Item No. Report of the Head of Planning, Transportation and Regeneration**Address** 1 BRIXHAM CRESCENT RUISLIP**Development:** Single storey rear extension**LBH Ref Nos:** 20332/APP/2021/1732**Drawing Nos:** 1/BC/May/004 (Proposed Ground Floor Plan)
Location Plan (1:1250)
1/BC/May/001
1/BC/May/002
1/BC/May/003
1/BC/May/004 (Existing and Proposed Site Layout)**Date Plans Received:** 29/04/2021 **Date(s) of Amendment(s):** 30/04/2021**Date Application Valid:** 17/05/2021**1. CONSIDERATIONS****1.1 Site and Locality**

Existing & Proposed Block Plan
1 Brixham Crescent
Ruislip Middlesex
HA4 8TU
1/BC/May/004

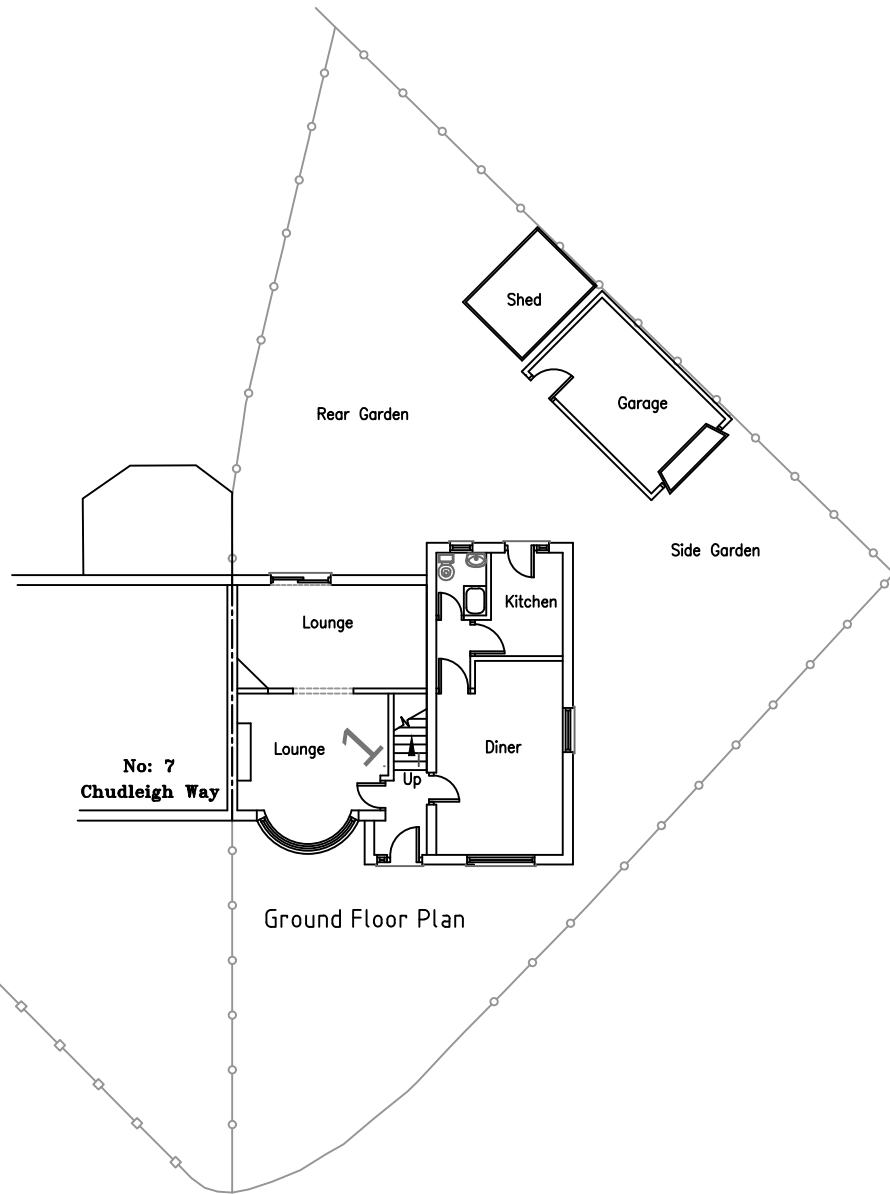
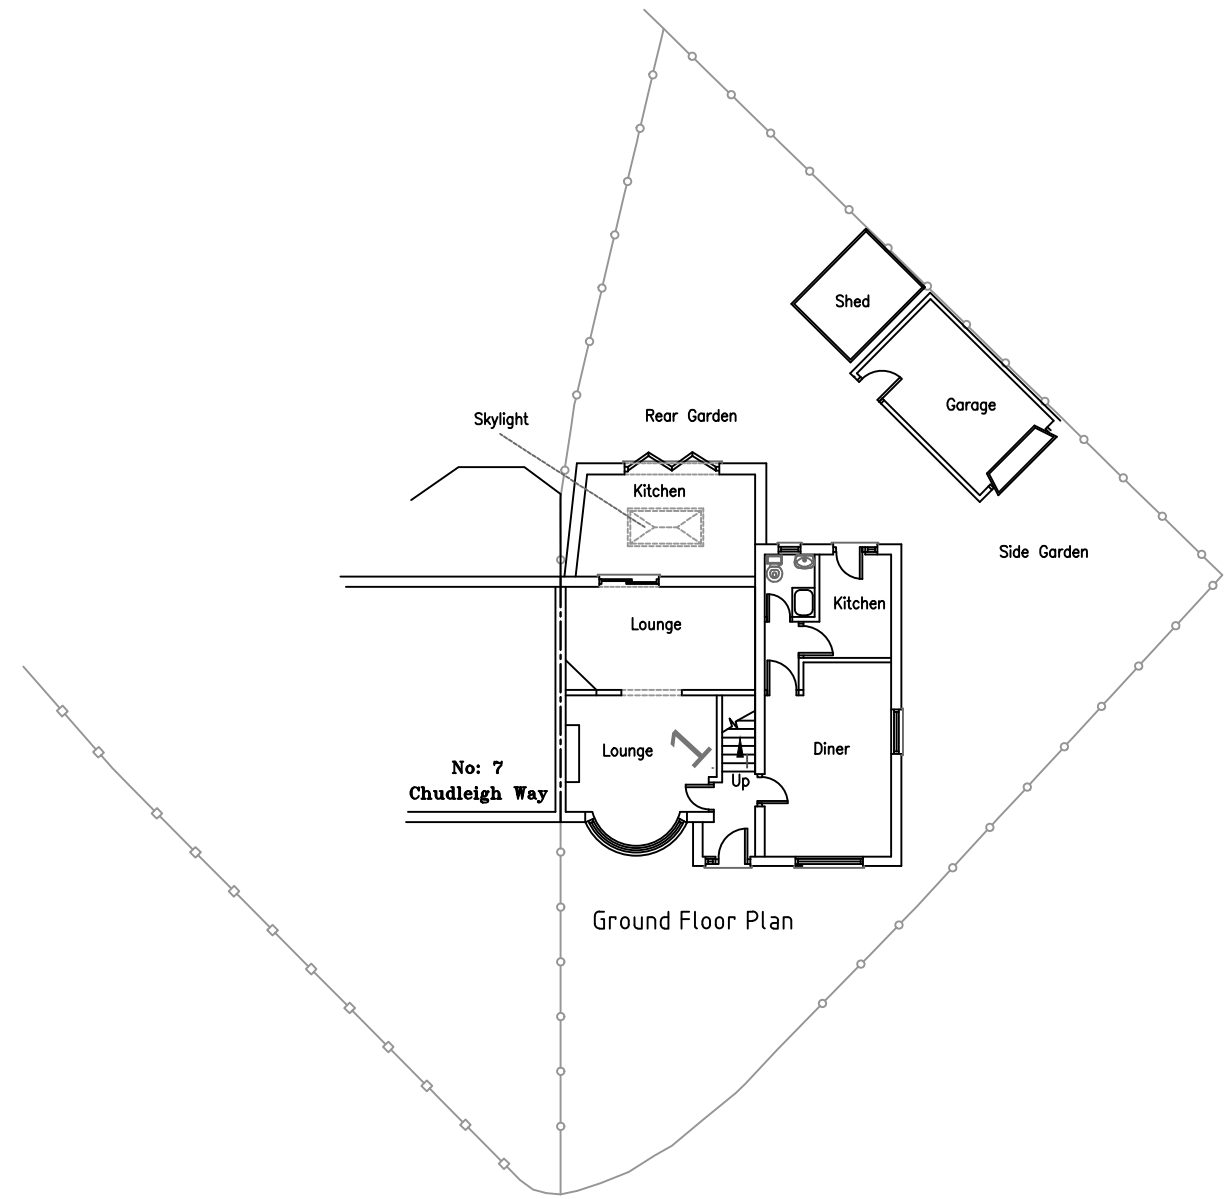
In terms of the garden area, the property is, at a minimum a 4 bedroom dwelling and thus, 100 sq.m would normally be required. In this case approximately 75sq.m would remain, which would be considered reasonable for everyday use and the site is within easy walking distance of a public open space at Shenley Park. Taking these factors into consideration, the level of amenity space provided is considered acceptable.

DRAWING TITLE:
Existing & Proposed Side Elevations

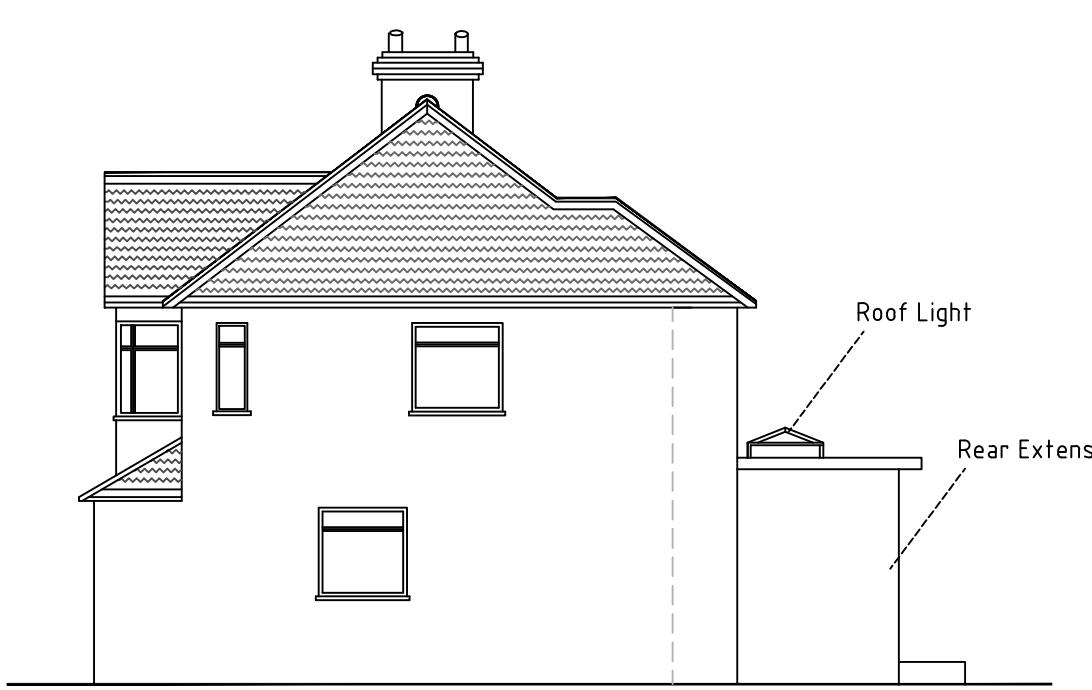
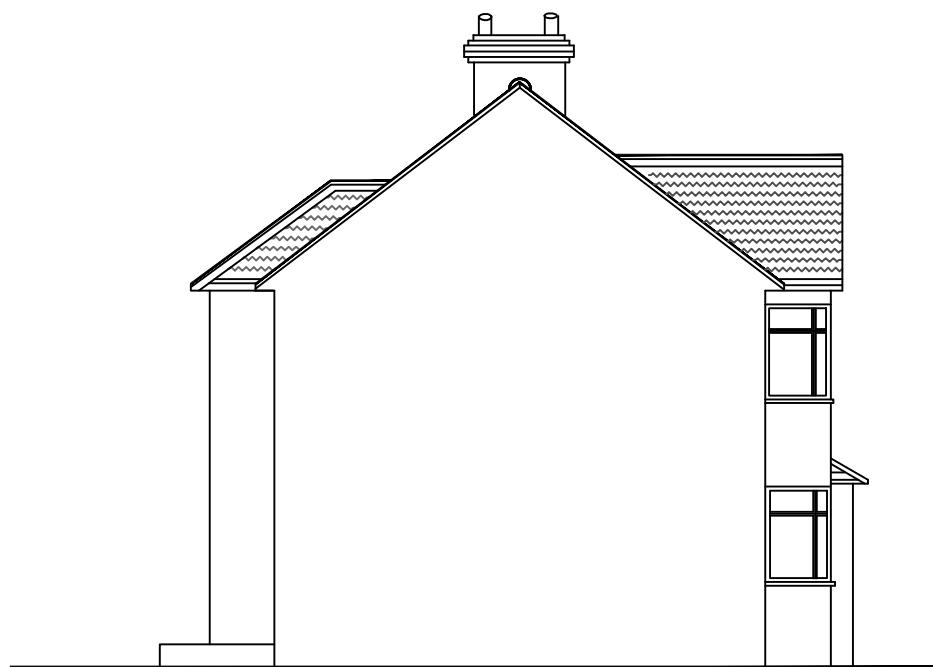
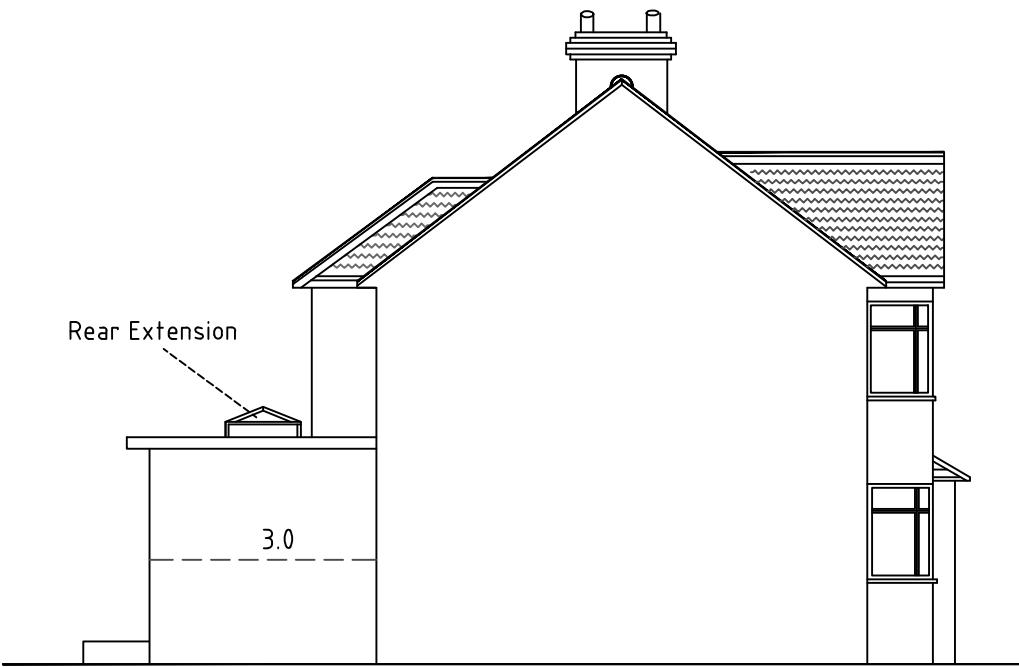
The boundary with the attached semi, 7 Chudleigh Way, comprises an approximately 1.8m wooden fence, with a rear conservatory to no.7 beyond. Given this screening and the 3m depth and height of the facing side elevation, it is considered no material harm would result to the amenities of this neighbour.

Notwithstanding the provisions of the Town and Country Planning (General Permitted Development) Order 2015 (as amended) (or any order revoking and re-enacting that Order with or without modification), no additional windows, doors or other openings shall be constructed in the walls of the development hereby approved facing 7 Chudleigh Way.
